Recommendation Report for Planning Permission for Works or Extension to a Dwelling

REF NO: M/123/17/HH

LOCATION: Little Thatch
93 Middleton Road
Middleton on Sea
PO22 6DW

PROPOSAL: Two storey extension to existing building. Re-submission of M/71/17/HH

DRAWING 104 A
PROPOSED
FIRST FLOOR PLAN & ELEVATIONS
1:100
APRIL 2018

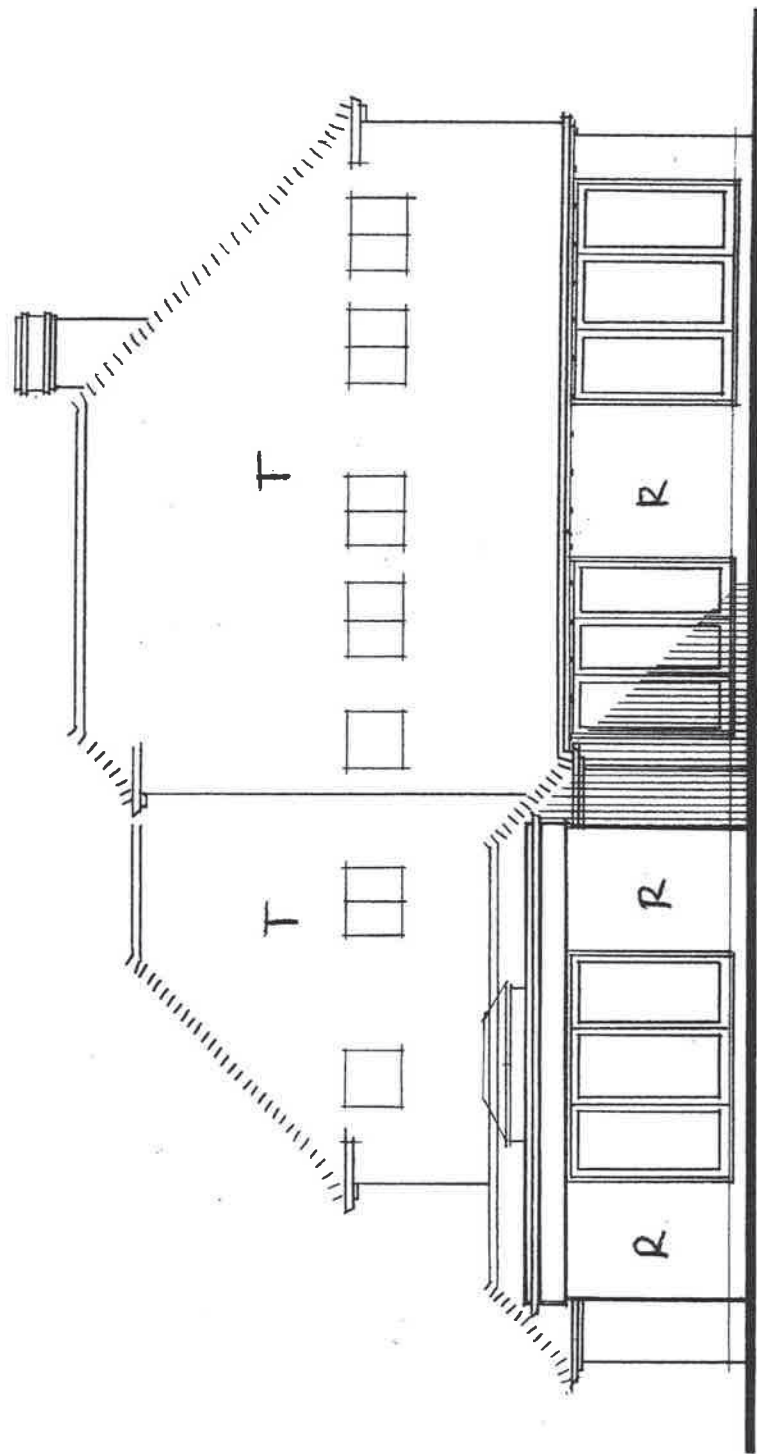
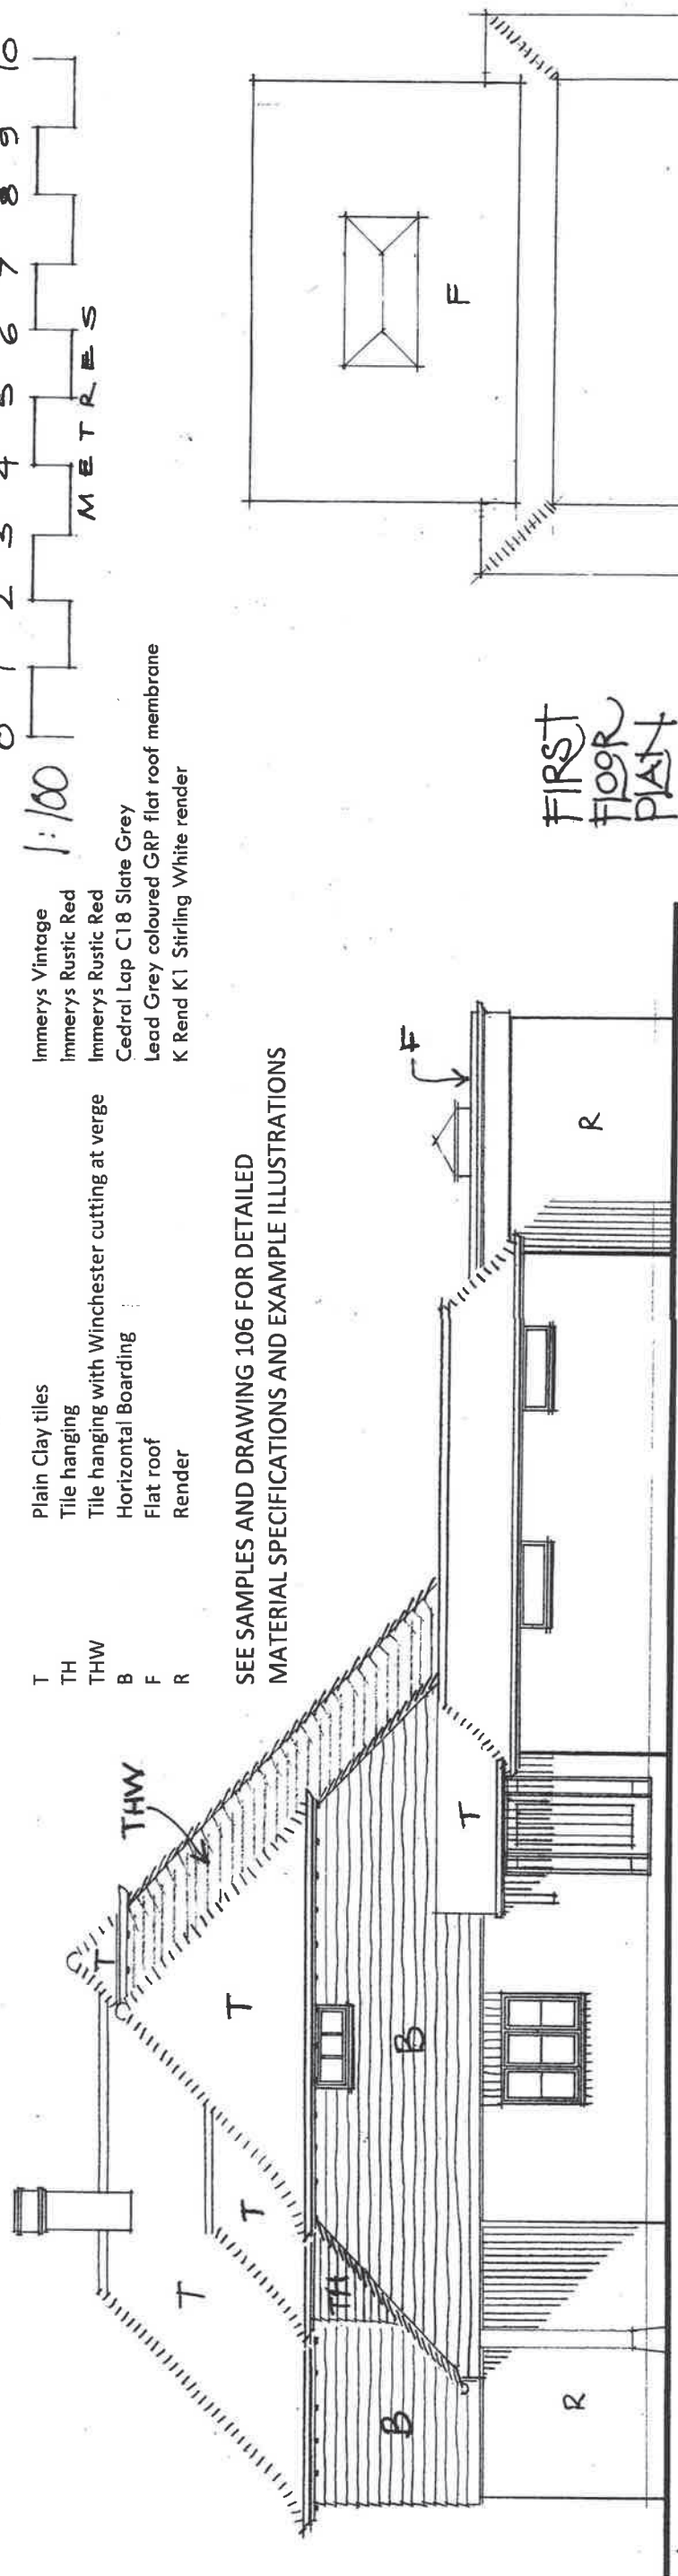
- The introduction of a first floor window on the east elevation whilst high level would still allow overlooking towards neighbours sitting out area and kitchen diner (with rooflights) and dormers above - these all face no. 93 and are within close proximity of the boundary. There would certainly be a perception of being constantly overlooked.

- The upper level window on the first floor plan does not tie up with the location shown on the east elevation drawing. The distance between the window in the dormer and the southern frame of the high level window do not seem to correspond.

A condition has been recommended to ensure that the first floor high level window in the east elevation is obscure glazed and a condition is suggested to prevent any further windows being added in this elevation in the future. This would prevent any adverse overlooking.

- 3 The window at first floor level on the east elevation of the building shall at all times be glazed with obscured glass and /fixed to be permanently non-opening up to a level of 1.7m above the finished floor level.

DRAWING 100

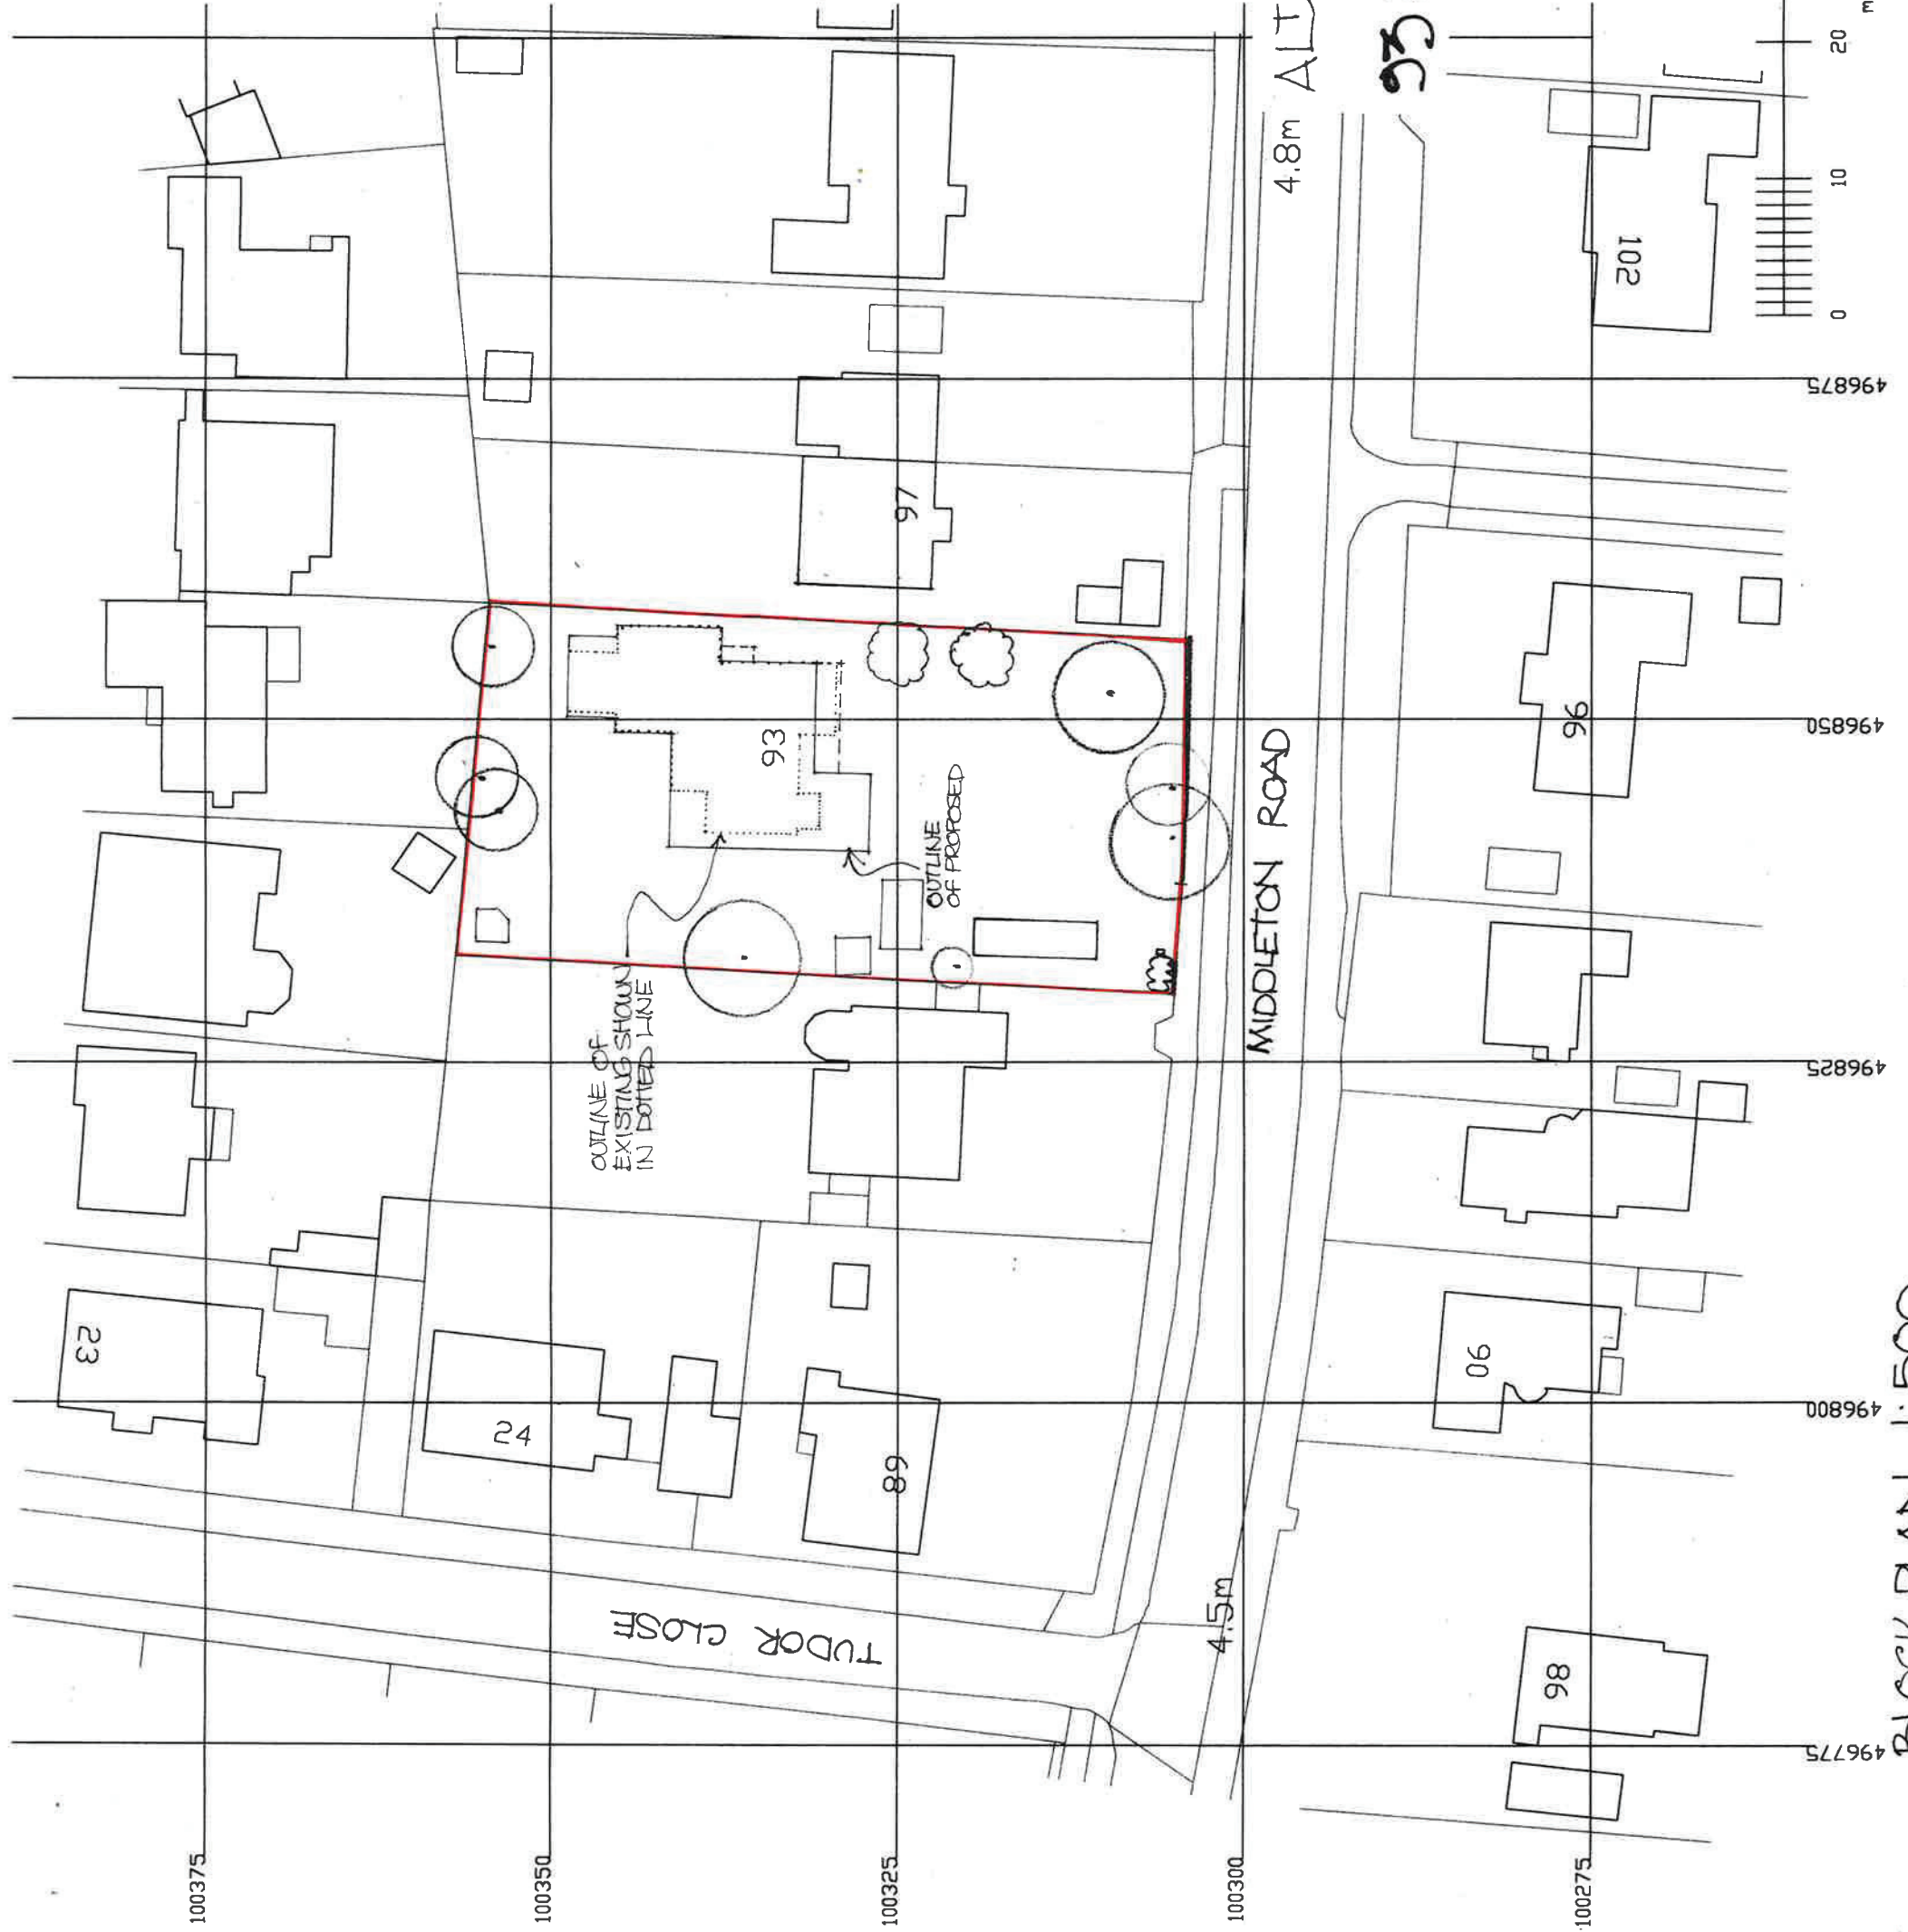
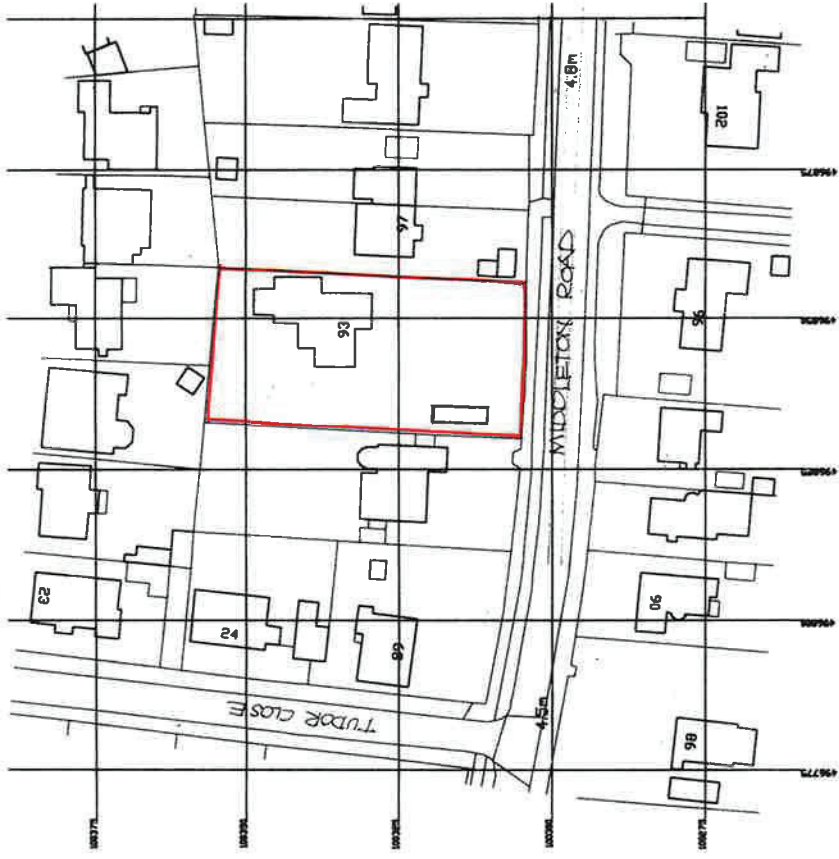
- Neighbouring property has not been included in the 1:500 Block Plan.
- The Location Plan is incorrect. Neighbouring house is not drawn to scale and is much closer to the boundary in reality.

- Question the 1m gap annotated on the plan. The block plan also shows the boundary to house gap as 3.3m. Drawing number AB-100-7 V5 - 'proposed floor plan and elevation' shows this distance to be 3.4m. It is therefore requested that key boundary measurements are double-checked on site.

- A new set of scaled plans have been submitted to now clearly show the distance to the site boundary. The site, including the existing and neighbouring property, have been professionally surveyed which means that all distances shown are as accurate as can be.
- There is no requirement for the plans to include the updated footprint of the adjacent dwelling which has

been extended. However clearer plans have been requested and received which show accurate distances from the proposal to the neighbouring property.
